Application number(s):	21/04275/OUT Part Parcel of land 8149- adj Lords Lane and SE of Hawkwell Farm, Lords Lane, Bicester			
Application site:				
Proposal:	OUTLINE - with all matters reserved except for Access - Mixed Use Development of up to 3,100 dwellings (including extra care); residential and care accommodation(C2); mixed use local centre (comprising commercial, business and service uses, residential uses, C2 uses, local community uses (F2(a) and F2(b)), hot food takeaways, public house, wine bar); employment area (B2, B8, E(g)); learning and non-residential institutions (Class F1) including primary school (plus land to allow extension of existing Gagle Brook primary school); green Infrastructure including formal (including playing fields) and informal open space, allotments, landscape, biodiversity and amenity space; burial ground; play space (including Neaps/Leaps/MUGA); changing facilities; ground mounted photovoltaic arrays; sustainable drainage systems; movement network comprising new highway, cycle and pedestrian routes and access from highway network; car parking; infrastructure (including utilities); engineering works (including ground modelling); demolition

No obje

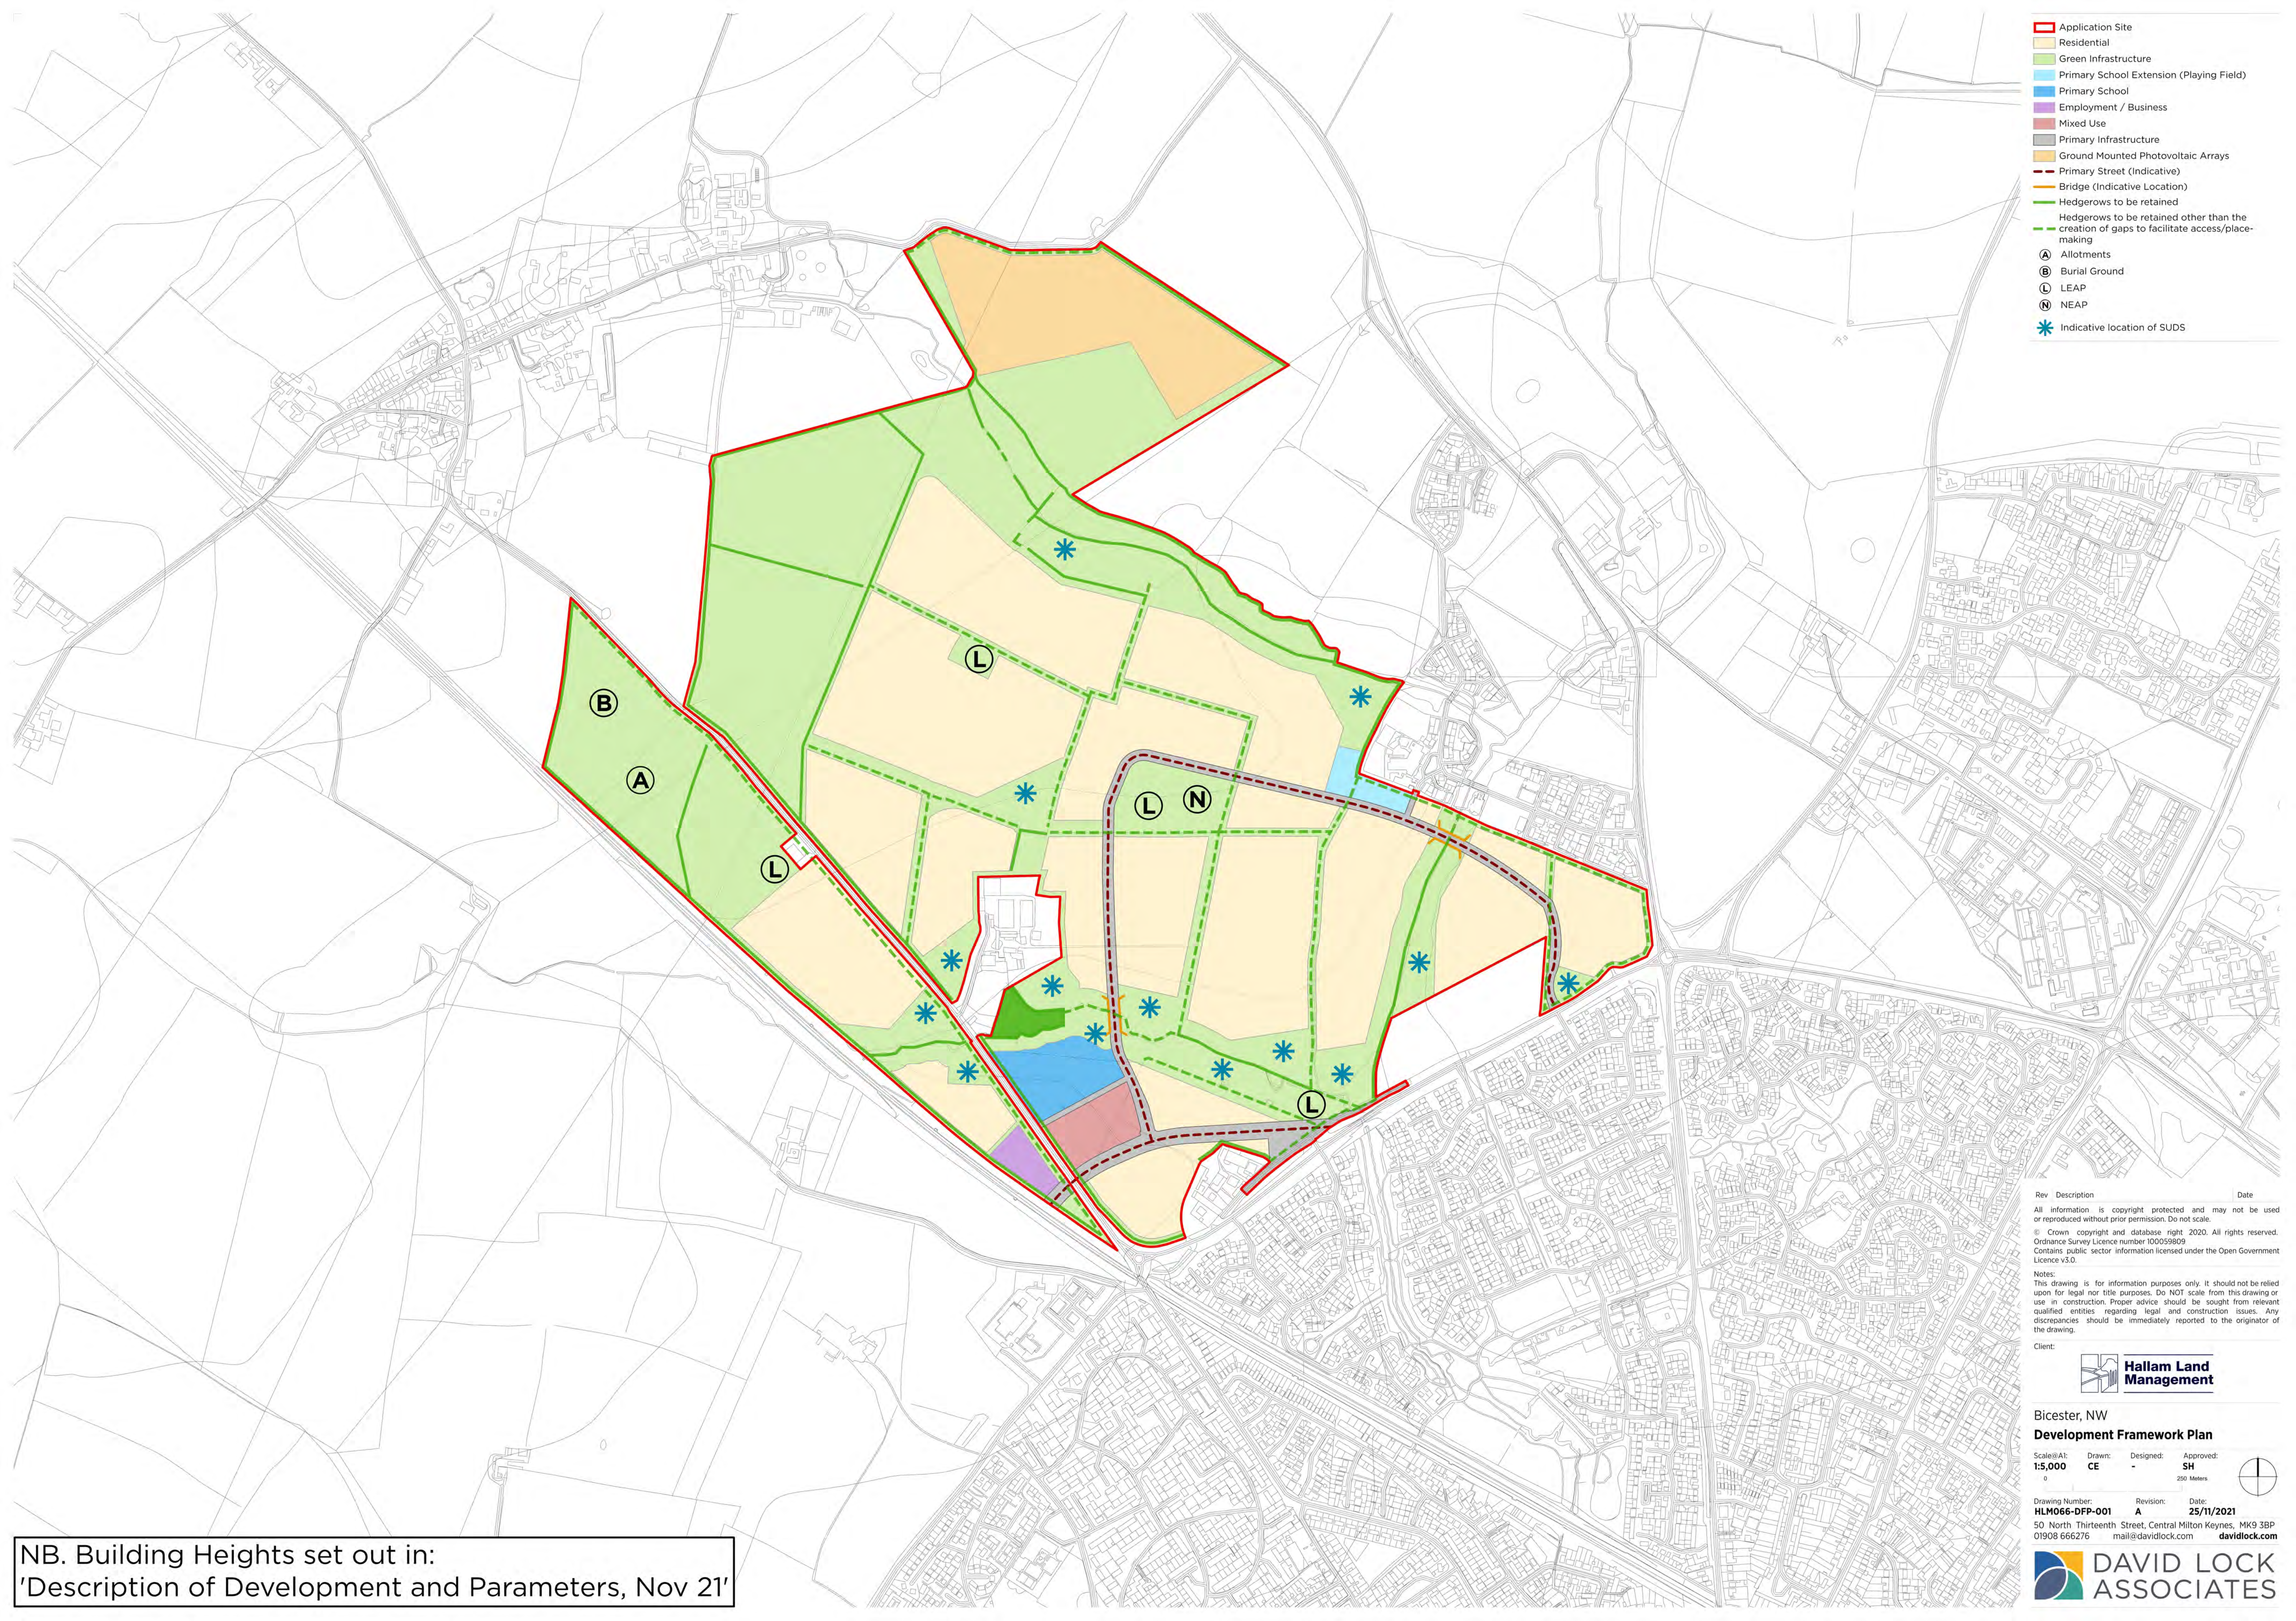
However, the photovoltaic panels and the housing in the north section appear to have a designated land use, on the submitted plans, for green infrastructure between the field to the south of the designated heritage assets and the area for solar panels also has a section between the boundary facing towards Lower Farm, Bainton Road, Bucknell.

The concern is that this has not been clearly set out in the submitted plans and only the access is fixed within the application.

It is recognised that it might be difficult to put to paper an exact layout for the houses and house types but the buffer green infrastructure areas particularly to the north around Bucknell should be clearly laid out in the application otherwise it is not possible to predict the impact on the designated and nondesignated heritage assets within the village of Bucknell. It would be appropriate is seek additional information where the which shows a high quality native woodland as a buffer zone between the village of Bucknell and the new development to protect the setting of the designated heritage assets found there in.

The need for a quality and reasonable large green buffer which would include a selection of large native broadleaf trees. This should be secured at this stage due to impact of the potential for the development to damage the wider setting of three Grade II and a Grade I listed buildings.
